Forest Services
East & East Midlands
Santon Downham
Brandon
IP27 0TJ

Re: Fosse Green Energy – Examining Authority First Written Questions (ExQ1)

Forestry Commission Interested Party Reference Number: [REDACTED]

FIGURE NUMBER REV.
 Figure 3-2B SHEET 2 01

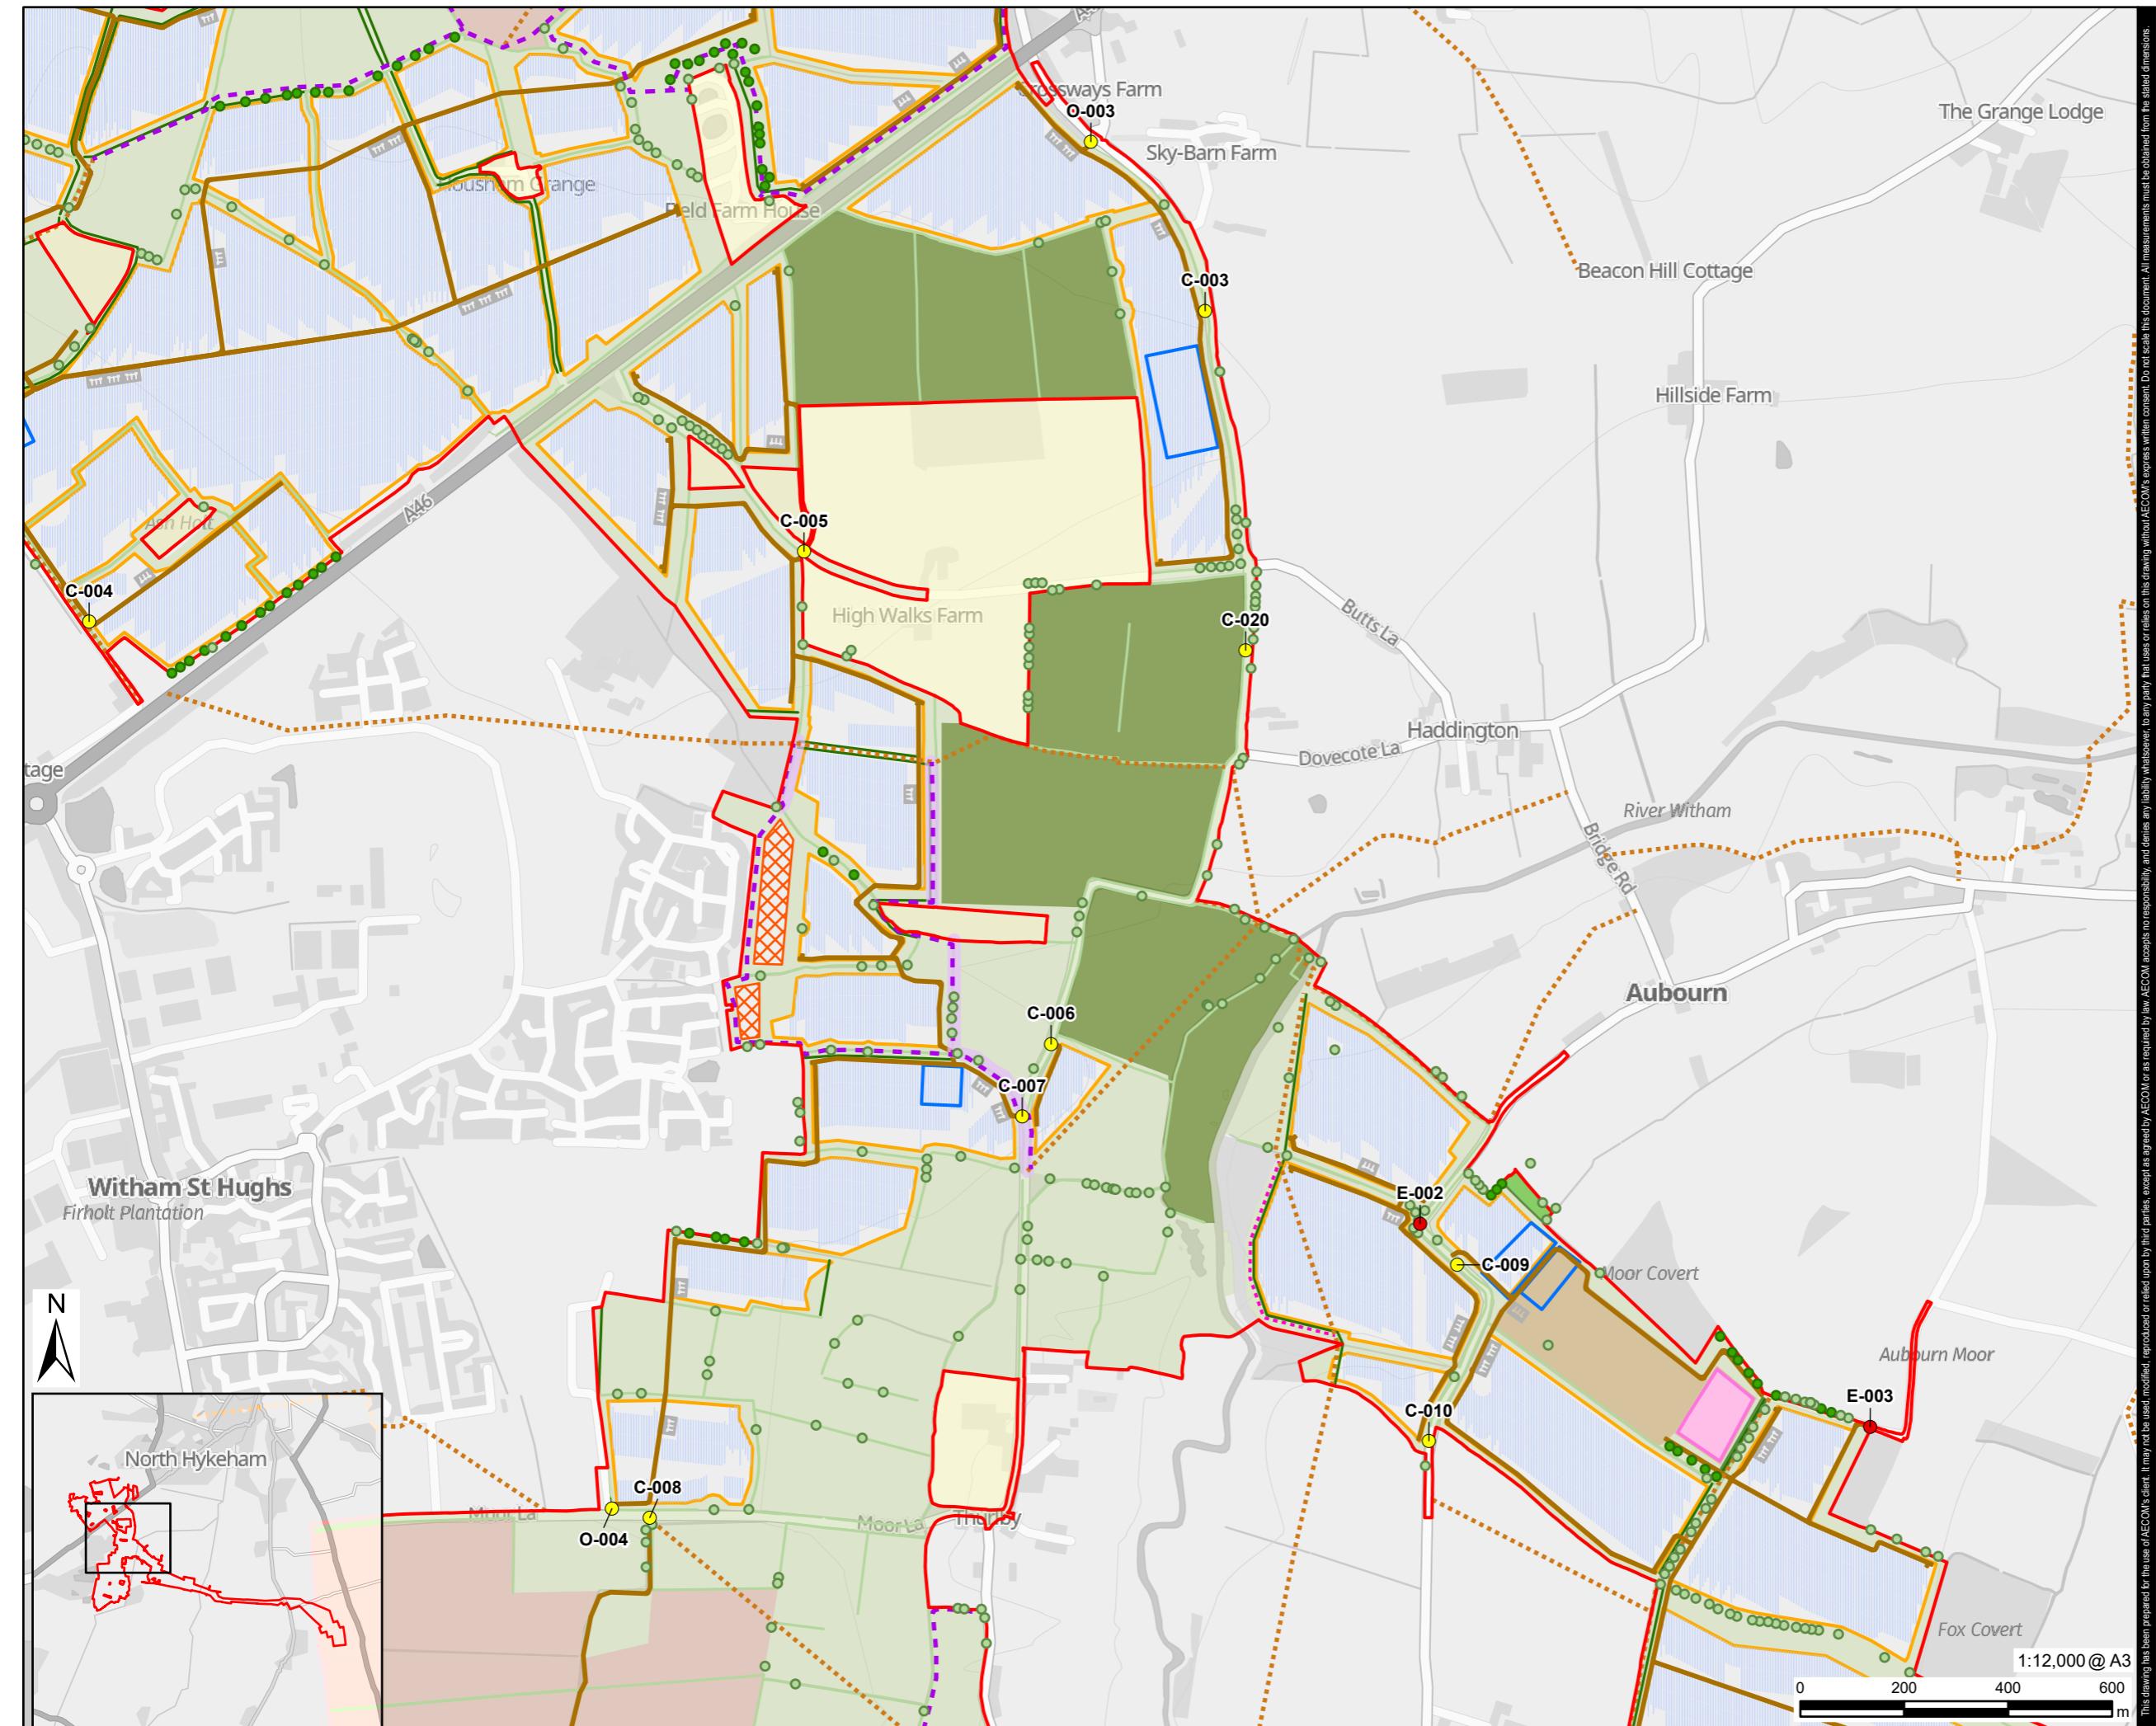
Our view is that significantly larger and well designed buffers with an enhanced woodland edge habitat and improved connectivity more broadly (through habitat creation and enhancement) is required to avoid degrading all affected woodland habitat.

We have however met with the Developer to discuss their plans and the buffer area around the ancient woodland. We are satisfied that the buffer area is nearer to 30m for most of the site with only some areas encroaching in closer, mostly for access purposes. However concerns remain that none of the planting proposals for the site are located near the ancient woodland which is being afforded a grass buffer.

The LNRS identifies the fields around the Ancient Woodland for buffering of the ancient woodland which would involve supplementary planting.

A larger wooded area, including woodland planting, scrub and woodland edge would provide better protection for the ancient woodland. Species such as bats, birds and invertebrates rely on woodland edge as foraging and commuting habitat. A bigger, better quality and better-connected buffer should be designed and maintained to protect the highly valuable woodland edge and maintain suitable habitat.
